Recommendation Report for Planning Permission for Works or Extension to a Dwelling

REF NO: AL/7/20/HH

LOCATION: Grindel
Level Mare Lane
Fontwell
PO20 3SA

PROPOSAL: Proposed single storey rear extension.

Drawing
PROPOSED FLOOR PLANS &
ELEVATIONS

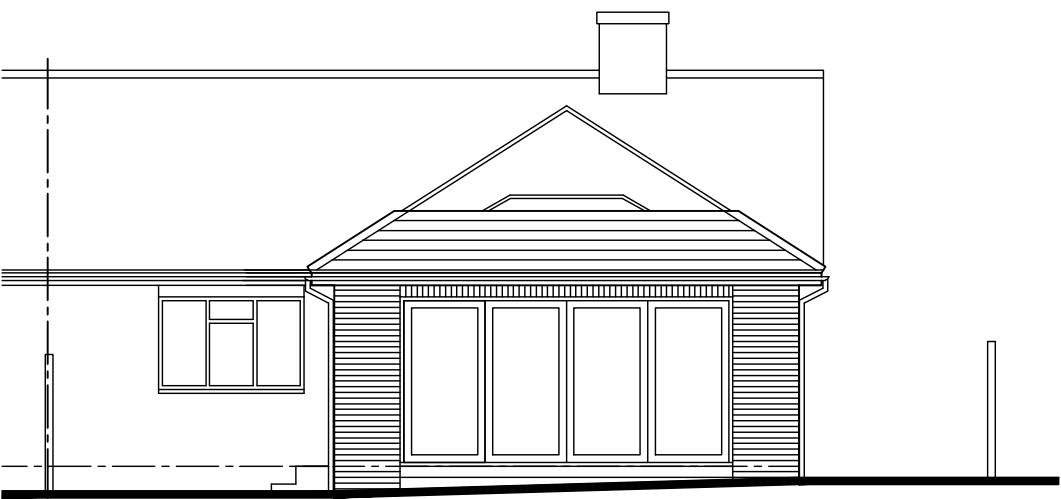
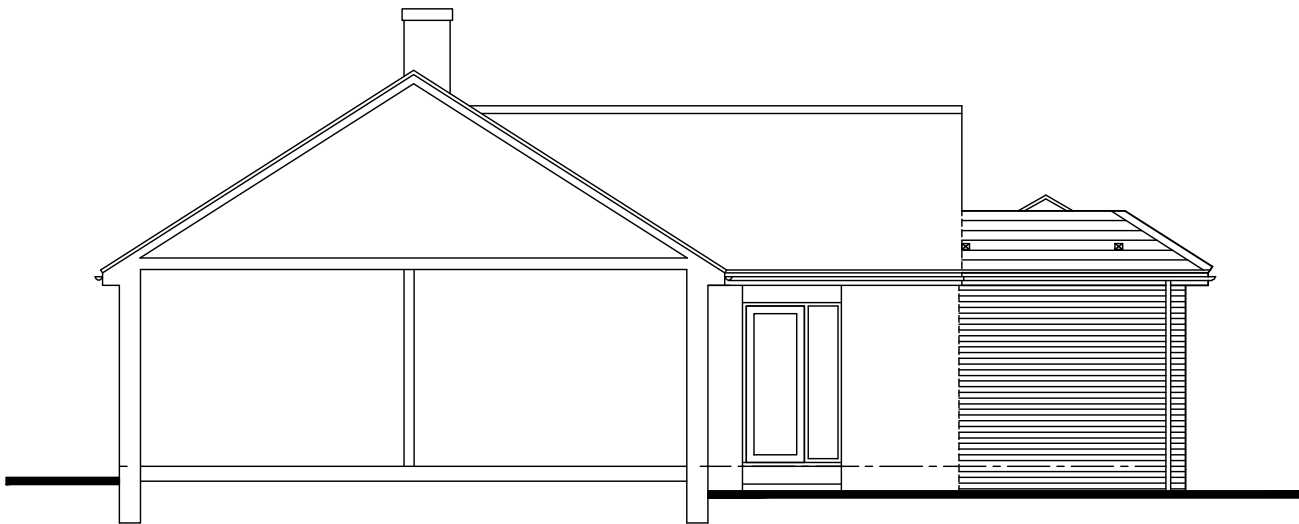
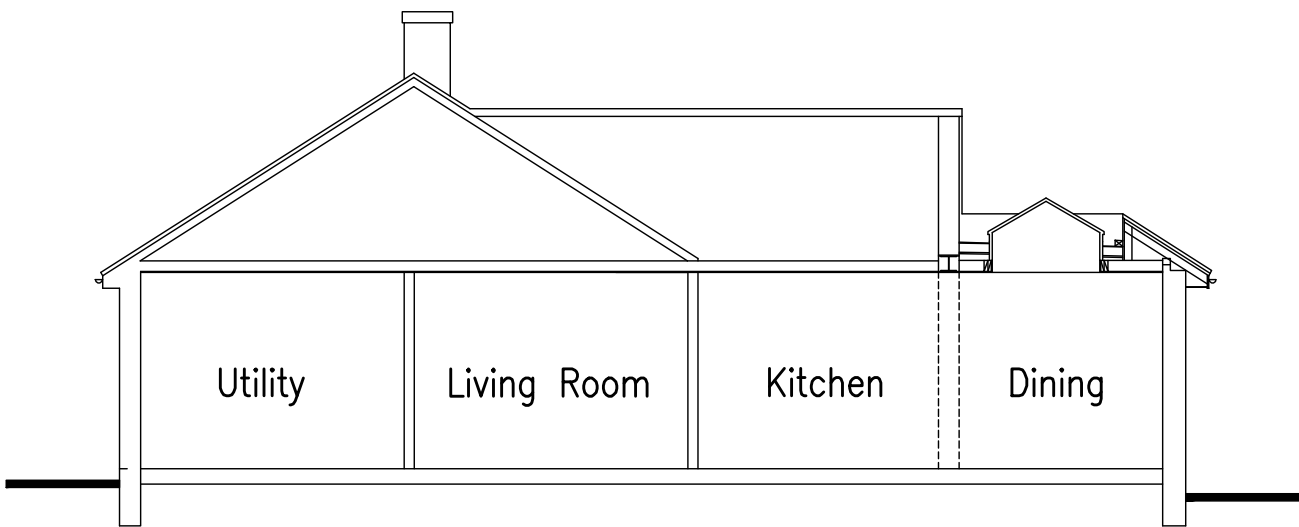
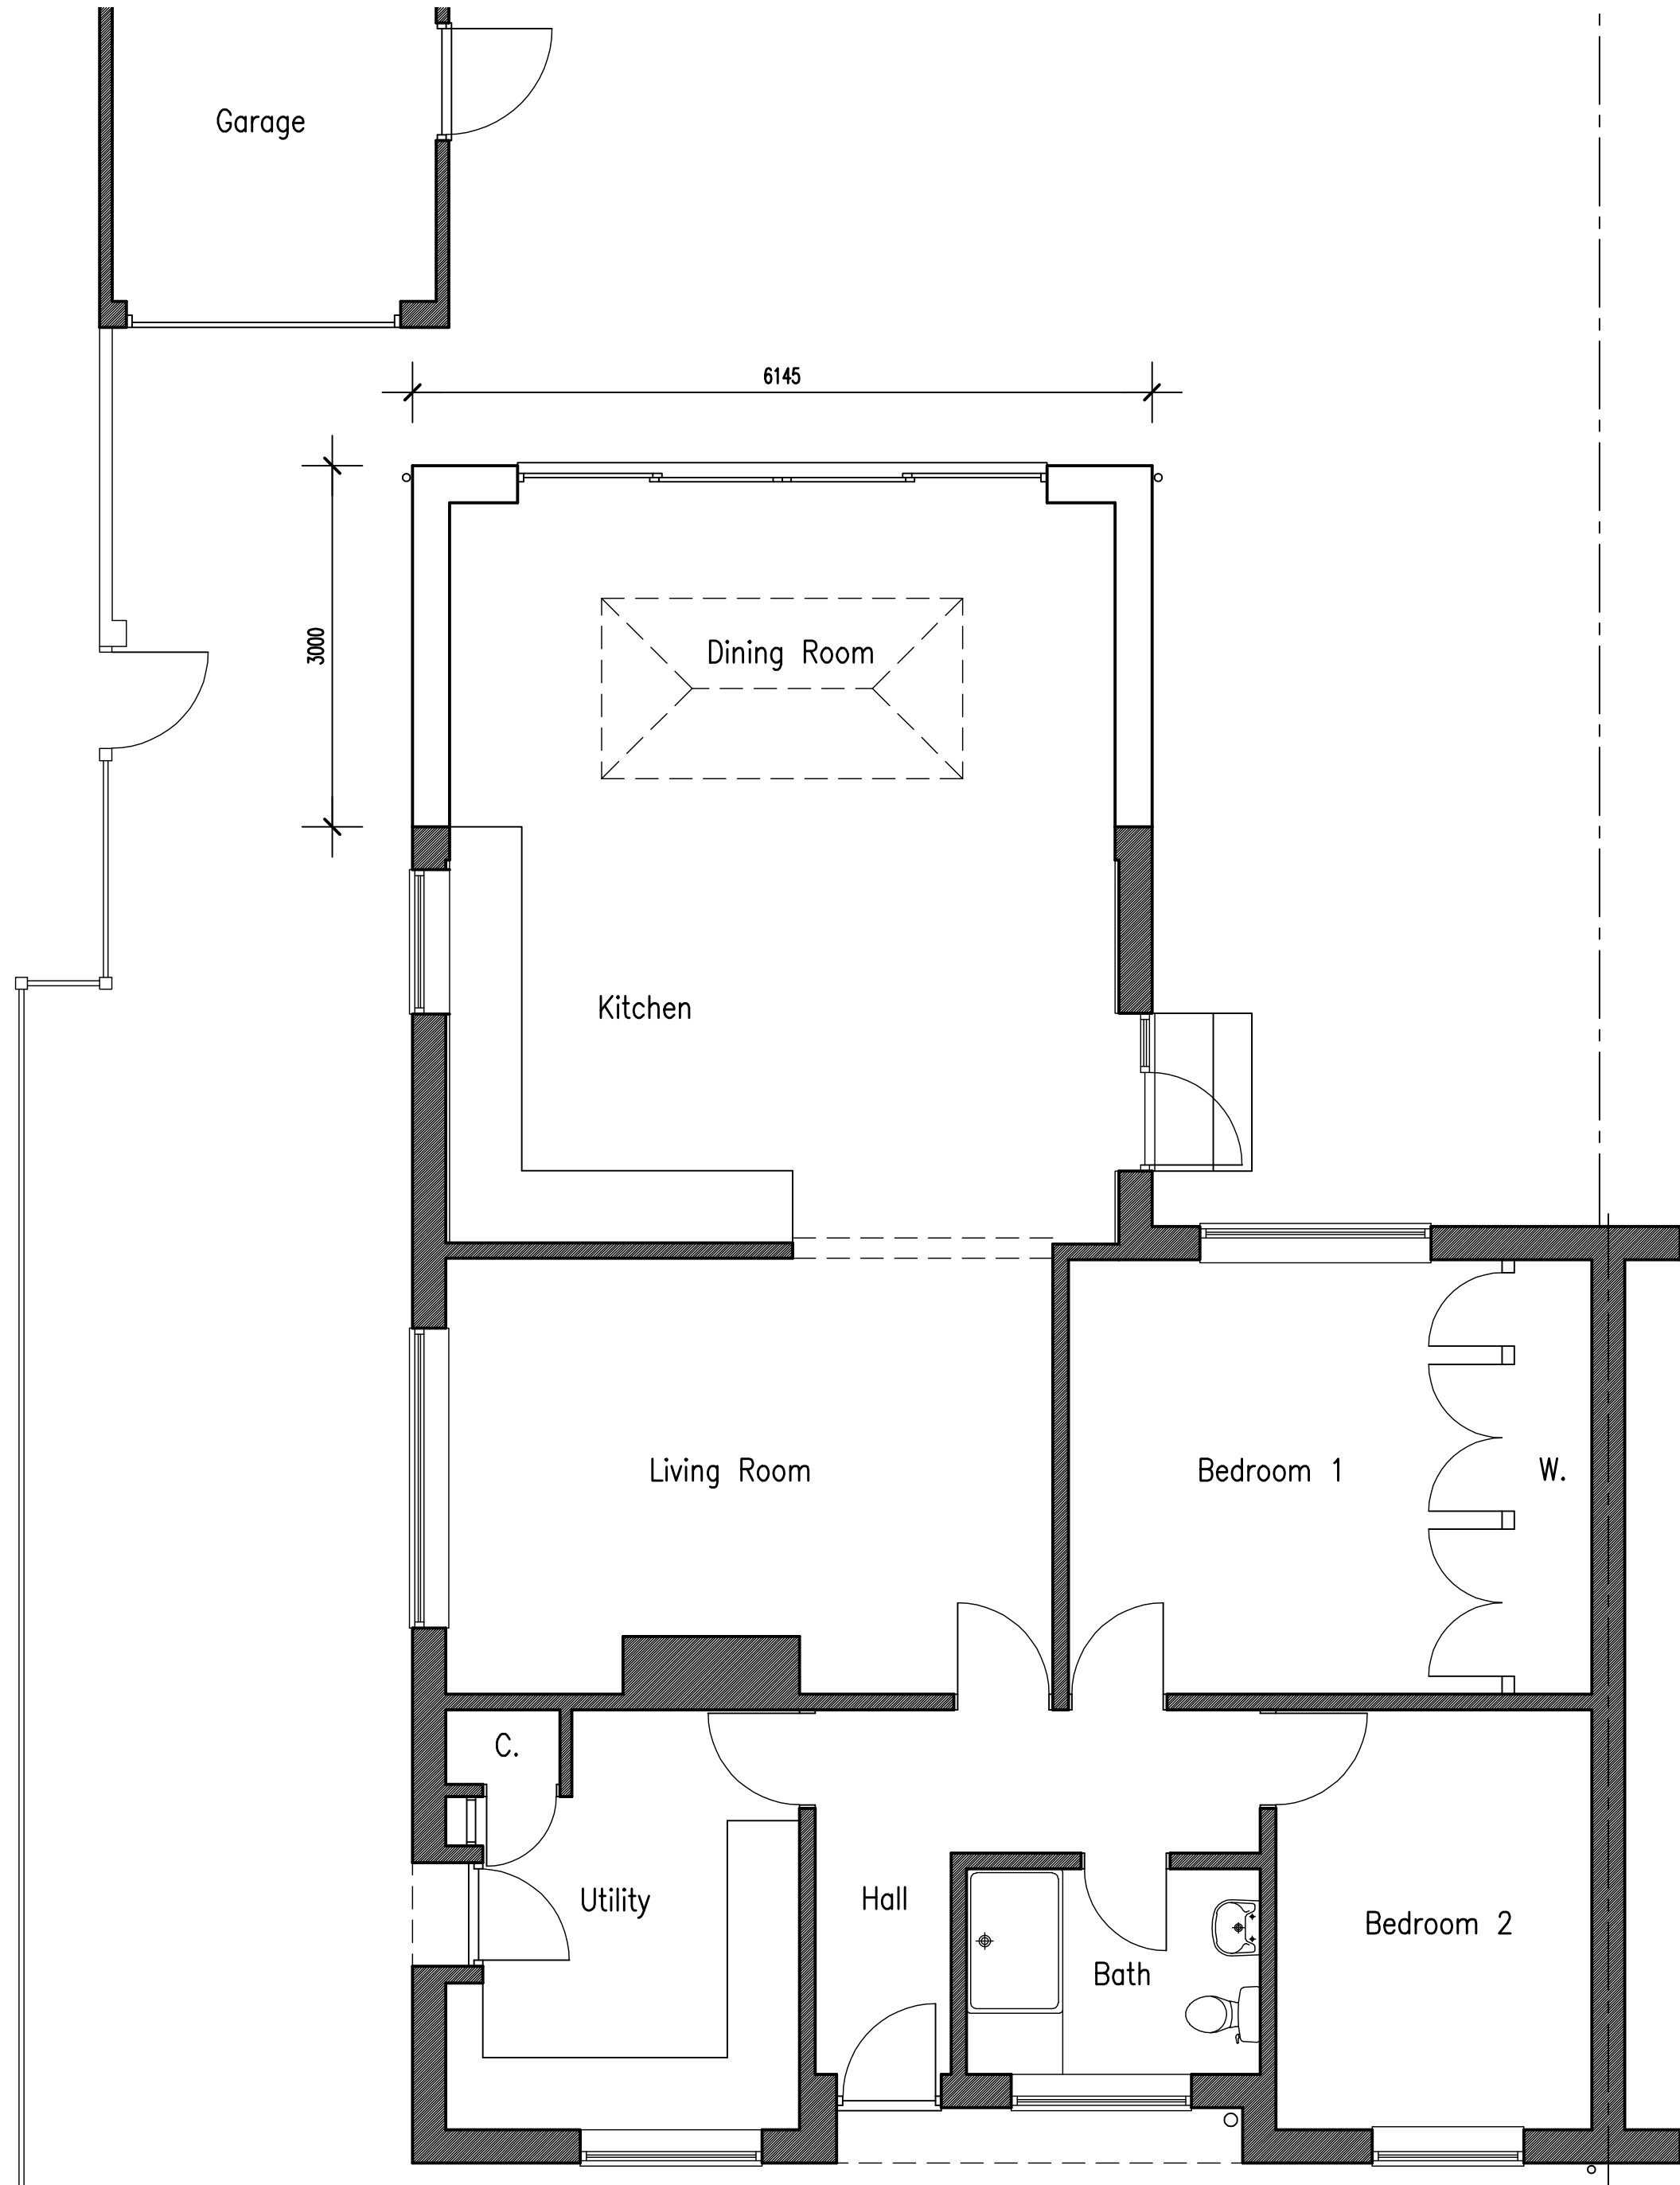
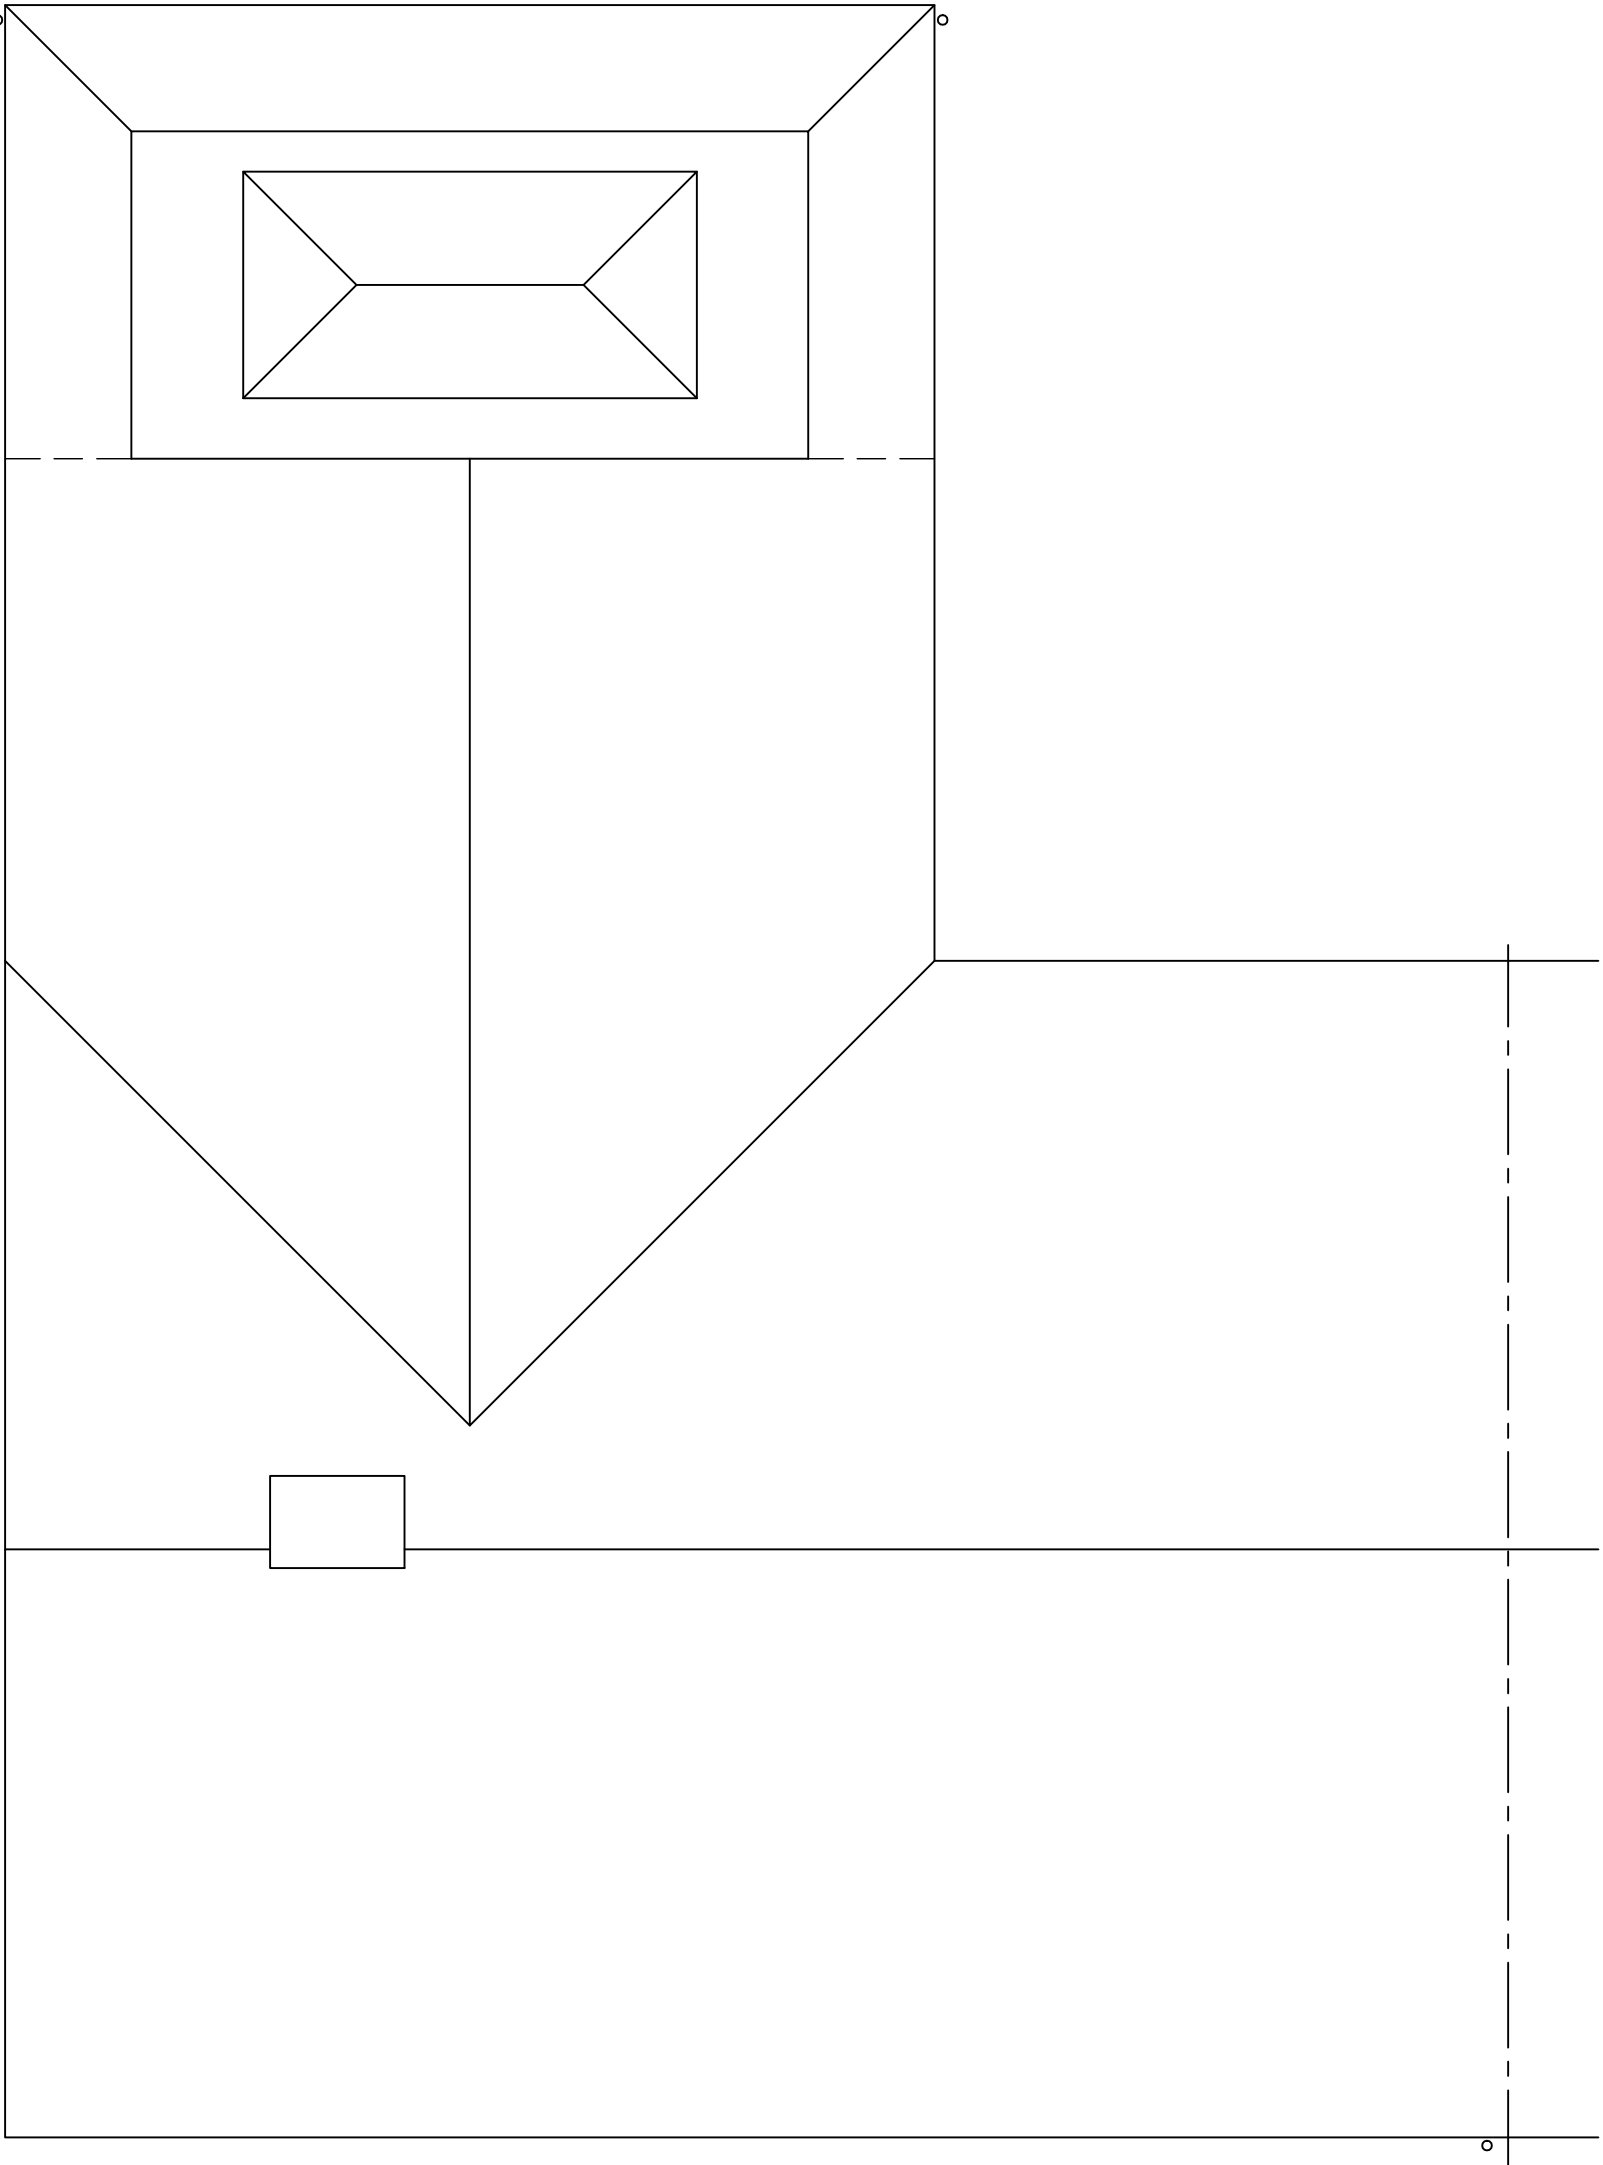
The extension is modest in size and appears subservient with the use of matching materials. The proposed roof is flat pitch with a rooflight to the centre whereas previously it extended in line with the gable end, therefore the overall height has been reduced.

The extension has a depth of 3m. It will have a height to the eaves of approximately 2.85m and a total height 3.75m with roof lantern.

The extensions retains 2.6m to the east and 3.4m to the western boundary. This is considered sufficient to ensure there is no adverse overbearing or overshadowing impacts. 30m is also retained to the rear boundary however there are no properties to the rear.
